From: Nolan, Chris <Chris.Nolan@lancashire.gov.uk>
Sent: 15 November 2017 14:18
To: Stephen Kilmartin; planning
Cc: LHS Customer Service
Subject: FW: D3.2017.0433 - Land off Henthorn Road Clitheroe BB7 2QF

Planning Application No: 3/2017/0433

Proposal: Application for outline planning permission for up to 25 new dwellings and associated infrastructure on land behind 115 Kemple View, Clitheroe including access via Henthorn Road.

Location: Land off Henthorn Road Clitheroe BB7 2QF

Indicative Initial Principles plan

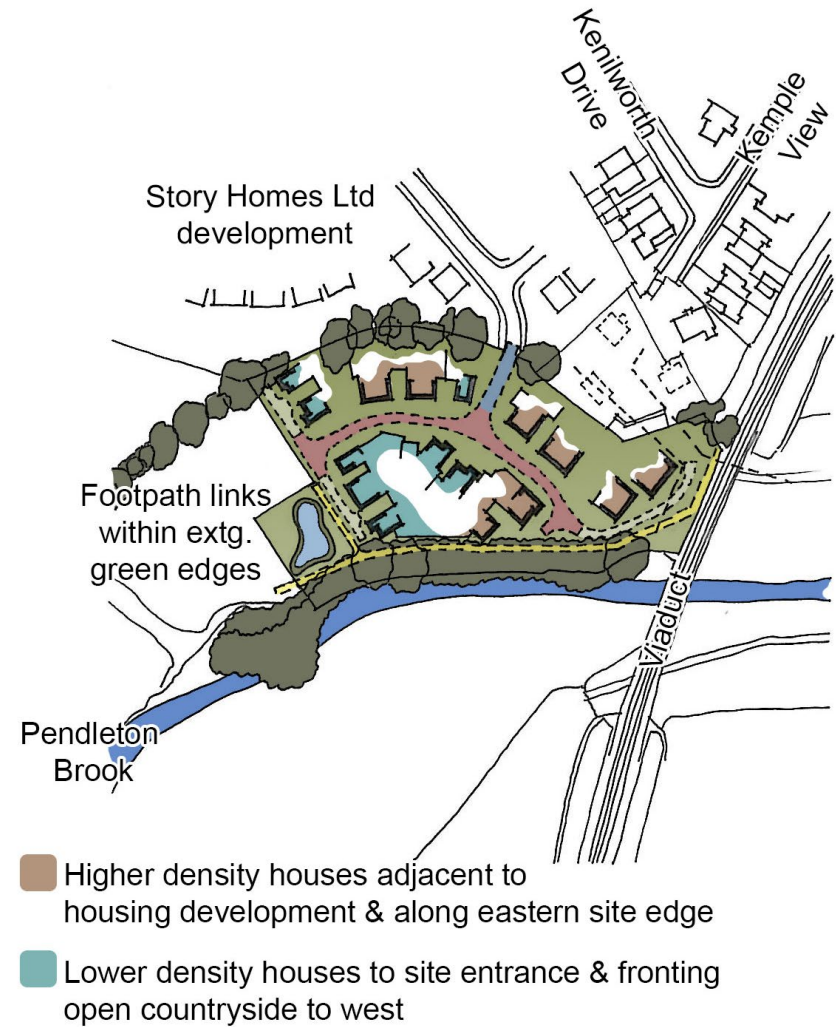
With regard to the revised indicative site layout plan we would be looking for a footway all the way around the estate roads as an amenity and to act as a service strip. This is detail that will need to be addressed when the reserved matters application is presented.
